Our Ref: TE06A11
Your Ref: MP 05_0174
29 November 2006

**Re: Proposed Oyster Lease Dredging, Wallis Lake
Project Application No. 05_0174**

**Proposed Oyster Lease Dredging - Wallis Lake
Project Application Number 05-0174**

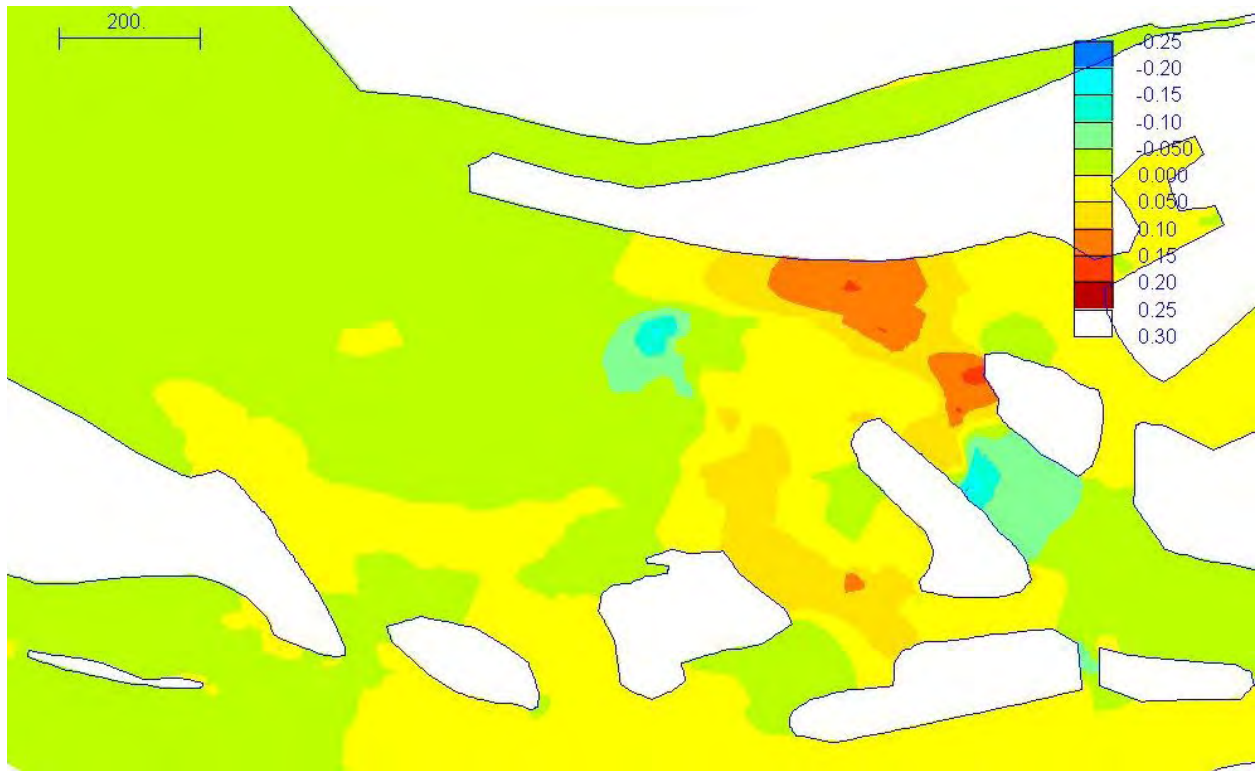
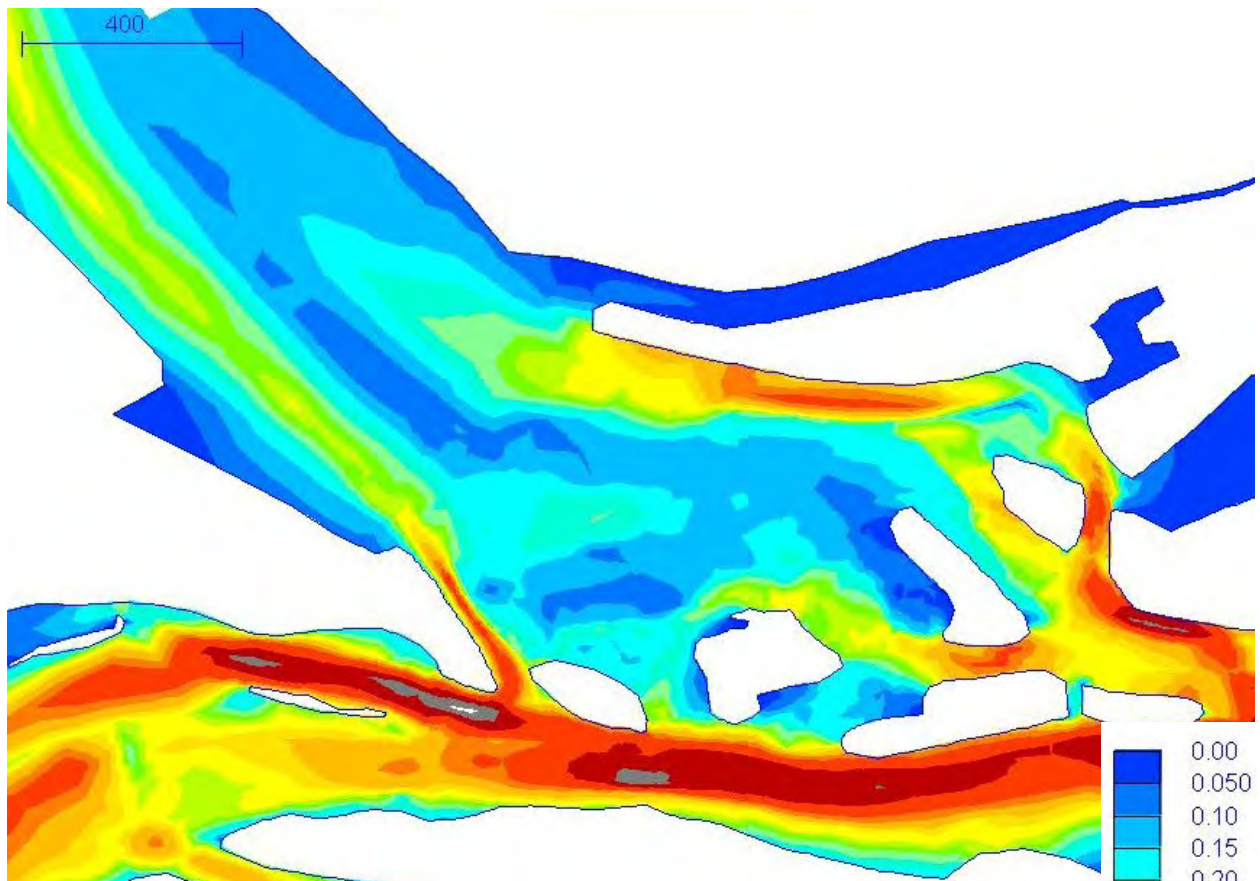
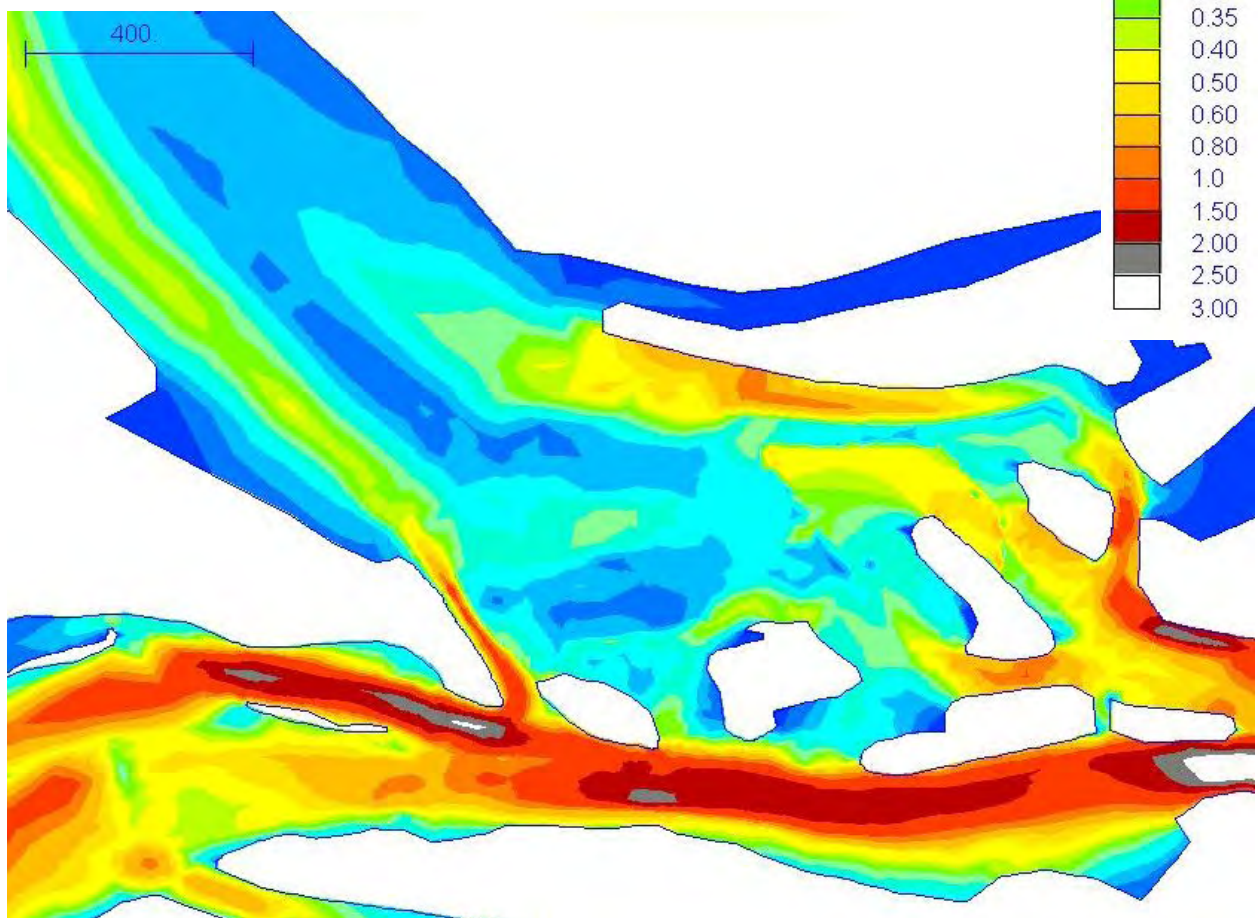
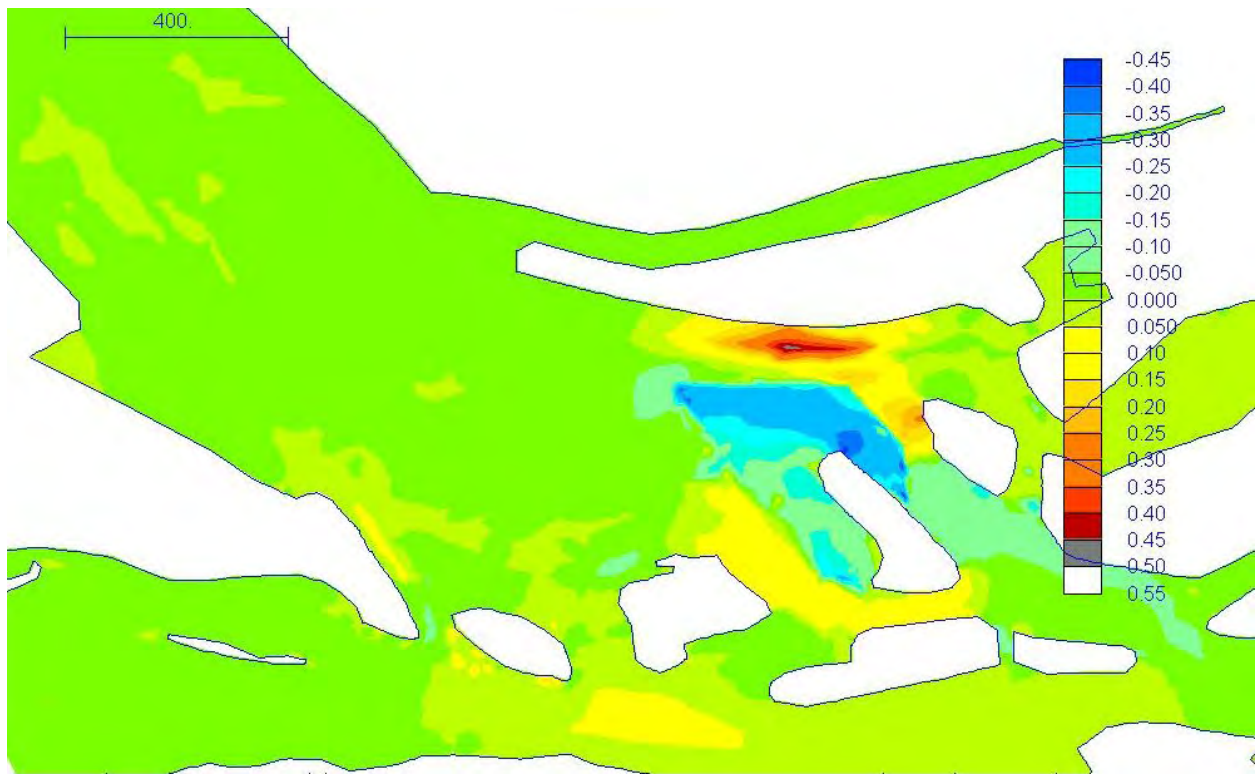
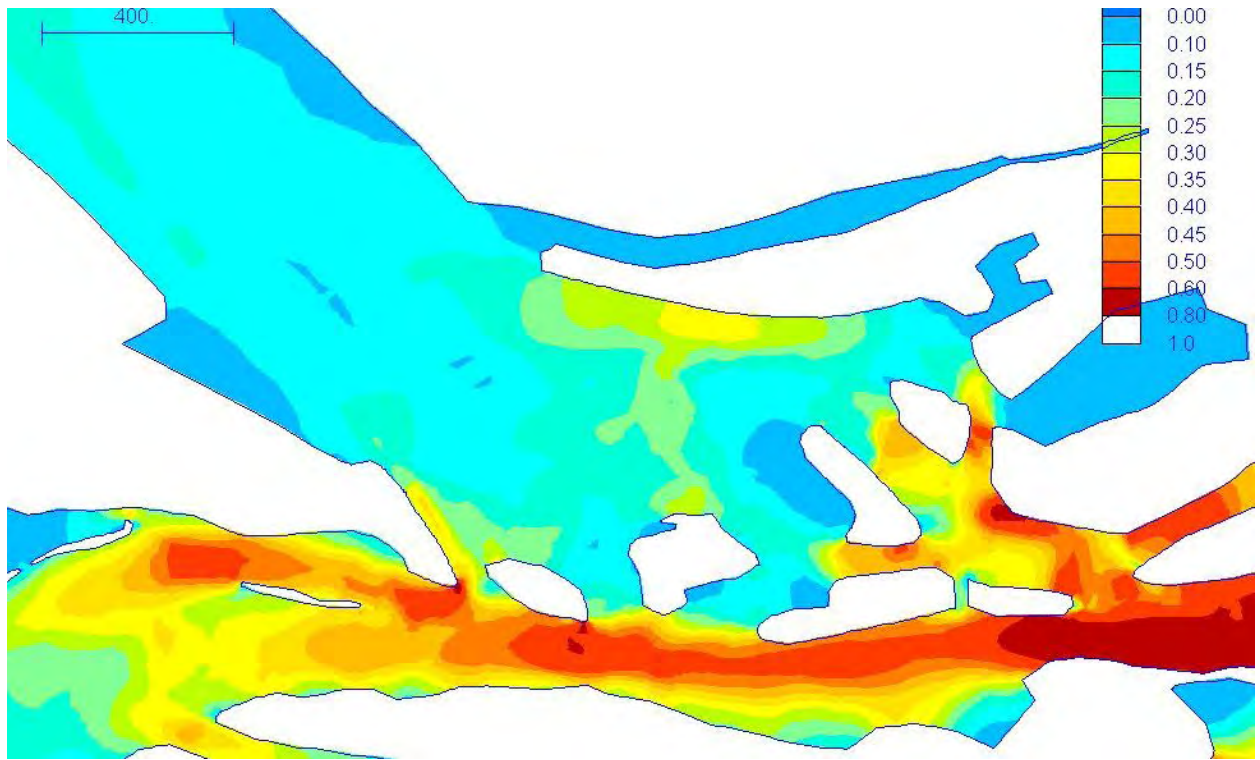
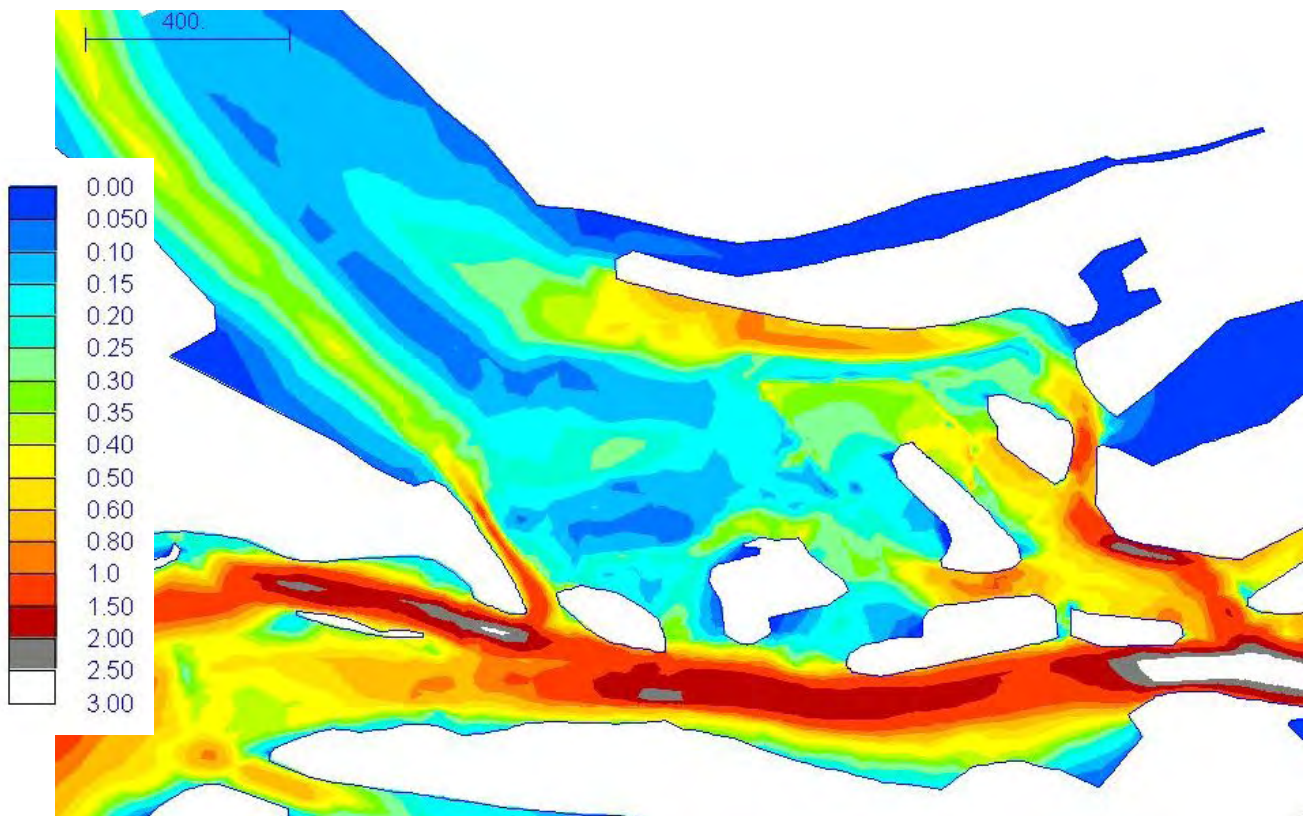
Fig 3.21 and Fig 3.23 outline the predicted changes in velocity and conveyance as a result of the current dredging proposal. The hydrodynamic model indicates that velocities and the conveyance of water will increase in sections of the channel between Native Dog and Oakey Islands with the potential for erosion upstream and downstream of the dredge area. If this erosion is to occur it has the potential to redirect further flows through the channel between Native Dog and Oakey Islands. It is likely that there will be corresponding changes in the conveyance of water through the channel to the east of Native Dog Island.

Although these predicted impacts may have limited effect on the flows or hydrodynamics of the overall Wallamba River and Wallis Lake estuary system as stated in the EA, it is likely that there will be localised effects.

- It is anticipated that the modelled changes in velocity and redistribution of flows may further exacerbate community concerns about shoaling in the vicinity of Jonnell Cove.
